AMBIENTAL ENVIRONMENTAL ASSESSMENT LTD.

Date:	20 October 2021	Contact name:	Steven Brown
Your reference:	Y/88/21/DOC	Telephone:	+ 44 (0) 203 857 8540
Our reference:	5877-AEA-ZZ-XX-CO-Z-0001	Email:	Steven.Brown@RHDHV.com
Classification:	Project related		
Enclosures:	Attenuation Calculations Updated drawing

The Green House Sussex Ltd, Lake Lane, Barnham, West Sussex, PO22 0AD.

Table 1: Arun LLFA Comments, and agreed resolution

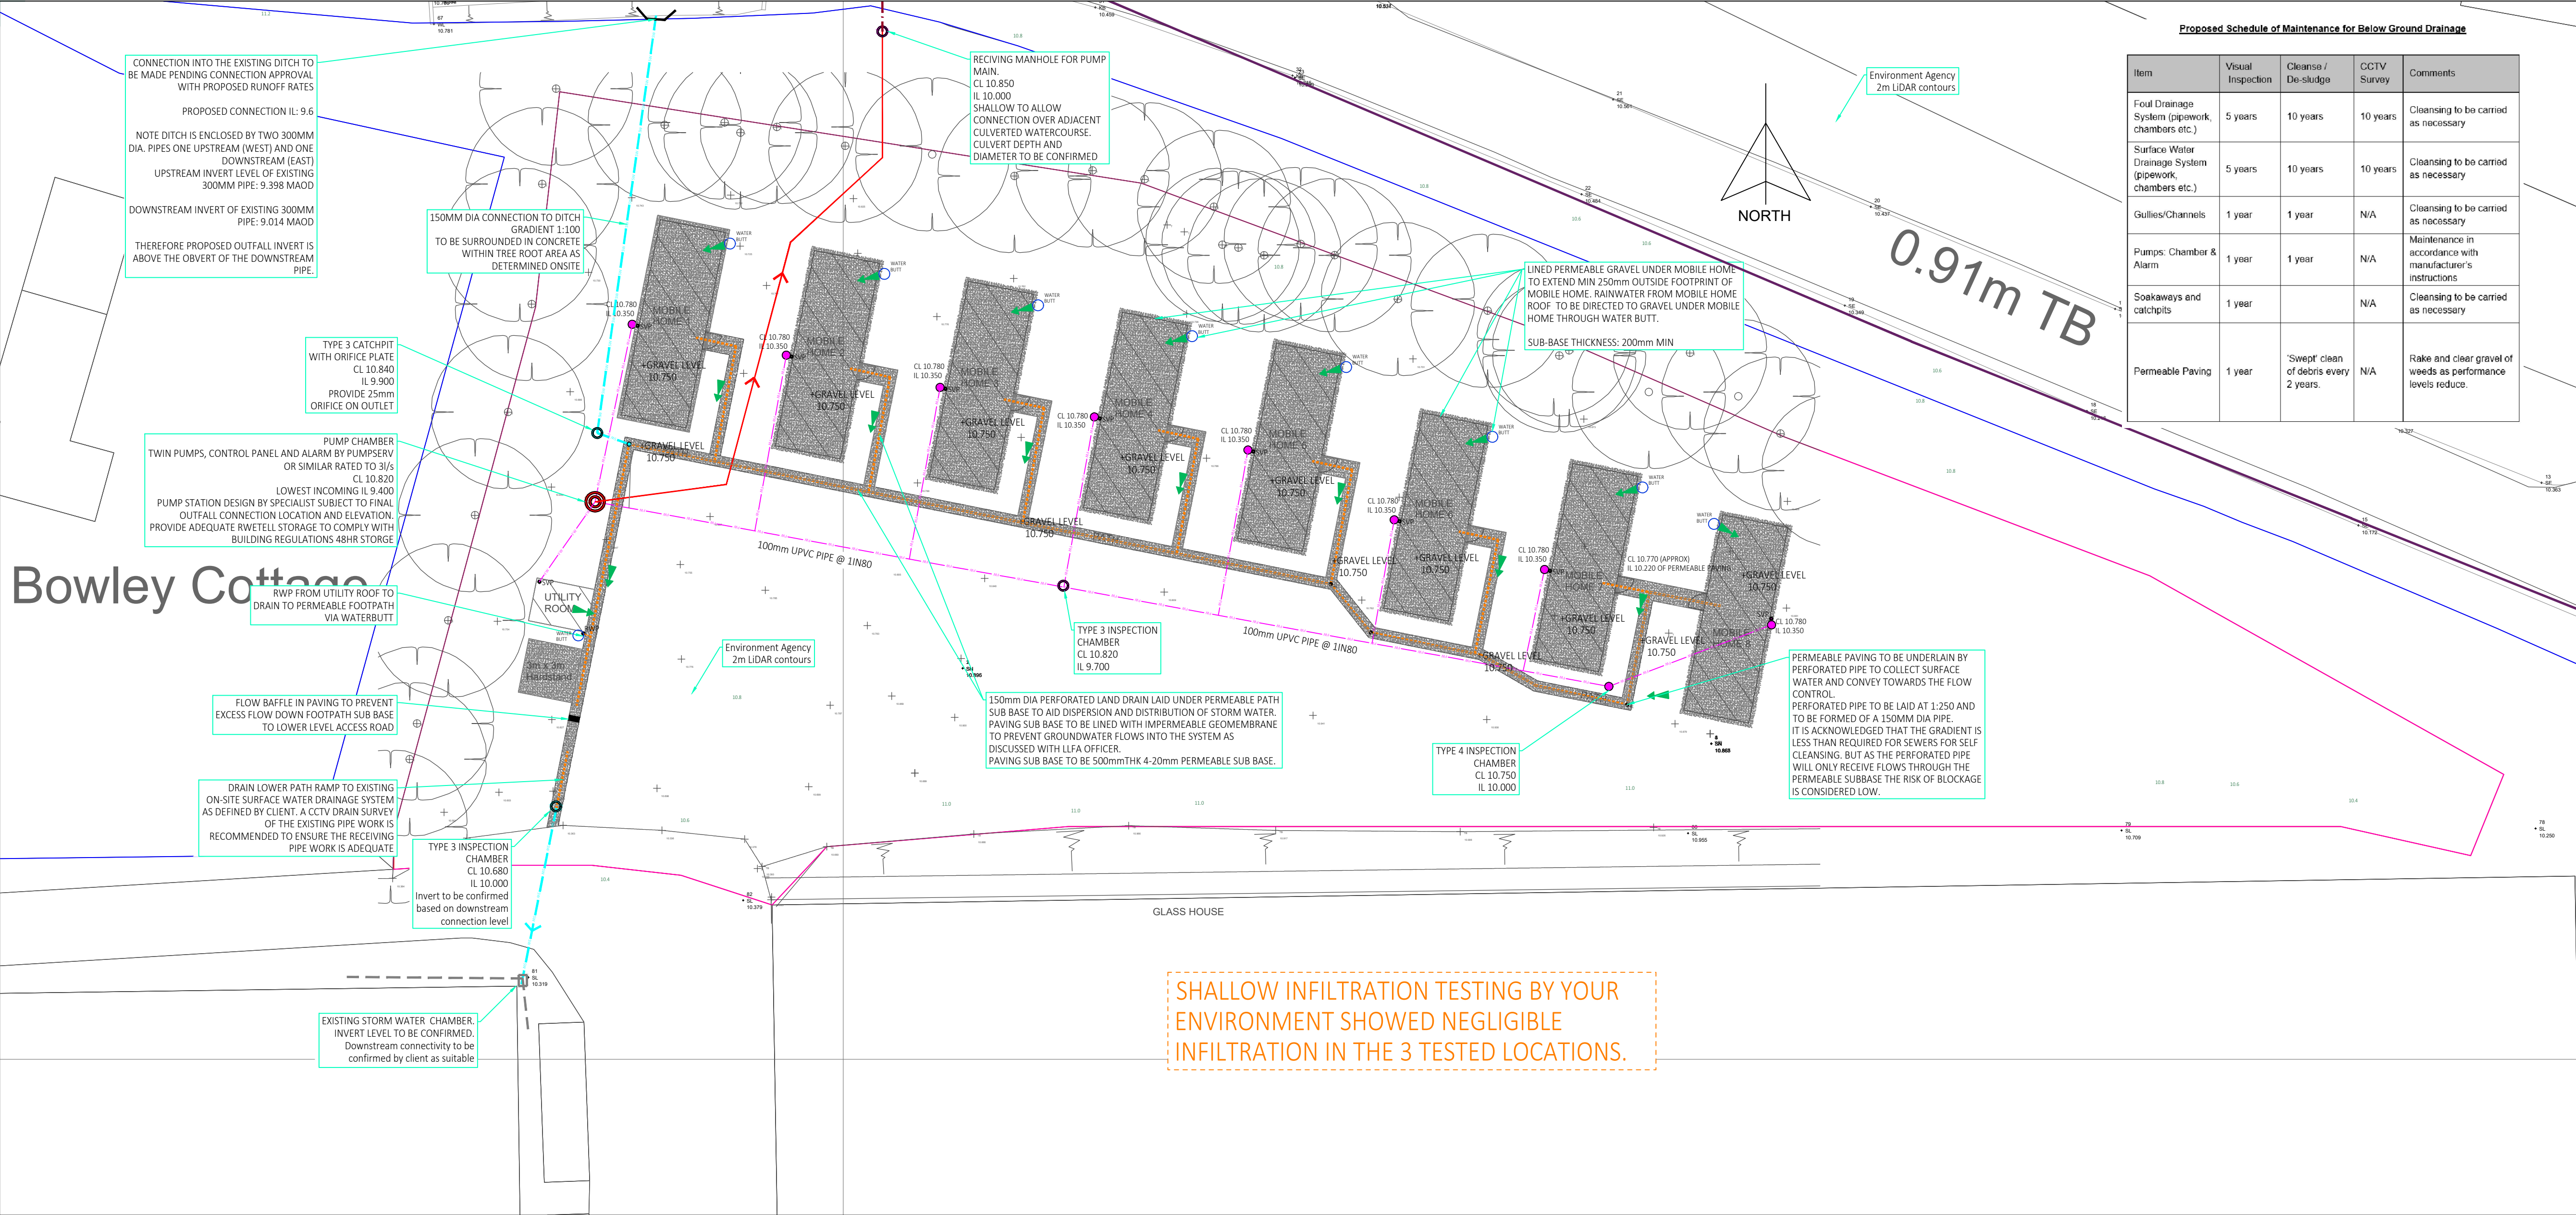
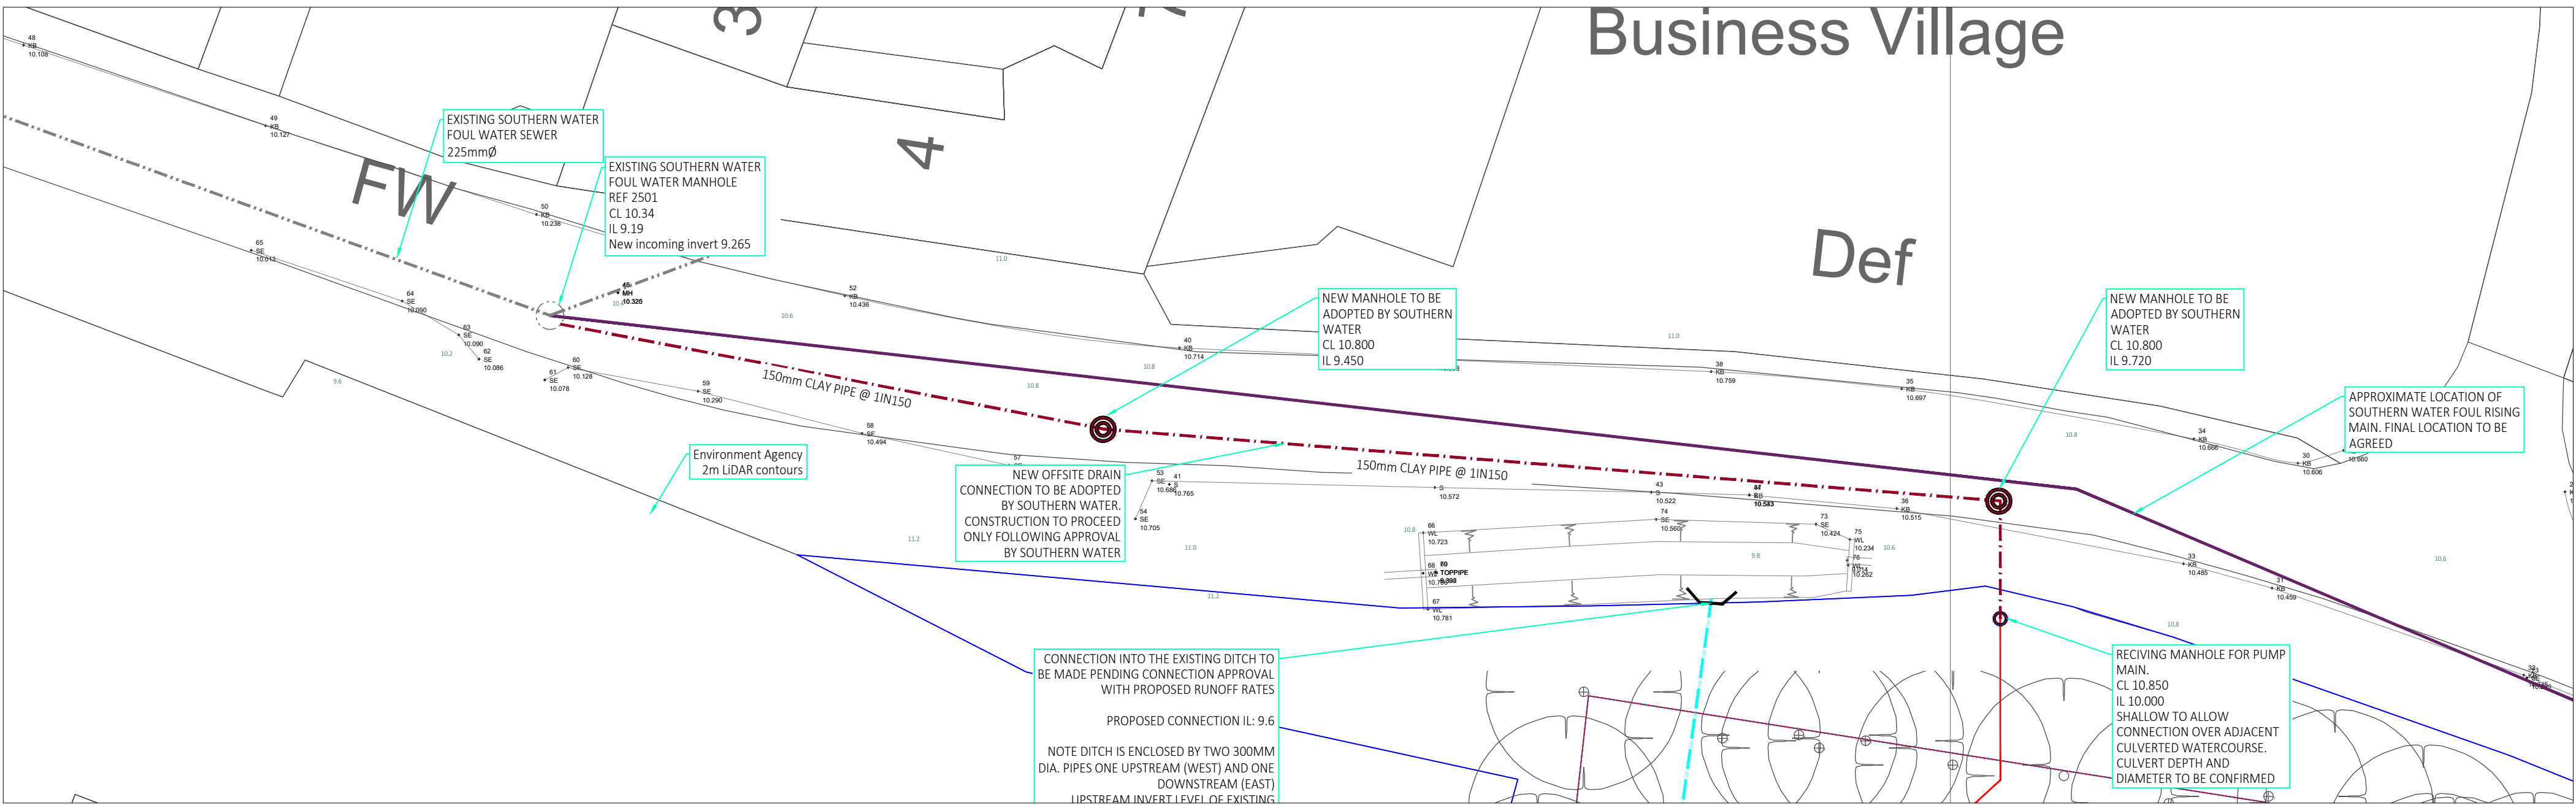
Arun LLFA Comment (05 October 2021, by Email)	Agreed Way Resolution
It appears that it is proposed to convey surface water through a granular sub-base. This is acceptable in principle, however a fall must be provided on the granular sub-base to promote conveyance. This fall should be reflected in calculations.	As it is proposed to include a perforated carrier pipe in/below the subbase it is not necessary to include a fall on the subbase. We will make it clearer on the layout drawing that it is proposed to have a perforated pipe, and this will include the pipe size and gradient.
A surcharged outfall should be modelled in calculations. With surcharged water levels equivalent to top of bank of watercourse.	To overcome the history of flooding that will result in a surcharge of an outfall, we will test the storage with a zero l/s outfall to simulate a flood locked outfall.
A 25mm orifice is proposed to control discharge rate from the site, this is quite small and could be prone to blockage. We query whether a hydro brake would achieve a similar flow restriction with a larger aperture?	The 25mm orifice is OK as it is downstream of permeable paving that will have a 20mm void which will mitigate the risk of blockage of the outfall

All surface water pipes must be labelled with diameter and fall.	A clear note will be included that all pipes will be 150mm Dia. and laid at a gradient of 1:100.
The true bed level at the point of connection to the watercourse must be provided, along with soft bed level.	It is proposed to construct the outfall above the obvert of the outgoing pipe from the ditch this should be above the 150mm clearance above the bed that Arun usually require
A concrete bed and surround will be provided where the pipes go through the trees.	This will be indicated on the drawing.
Site specific construction details of the flow control device and outfall must be provided.	The construction details for the flow control device and outfall will be updated to include the site specific cover and invert levels.
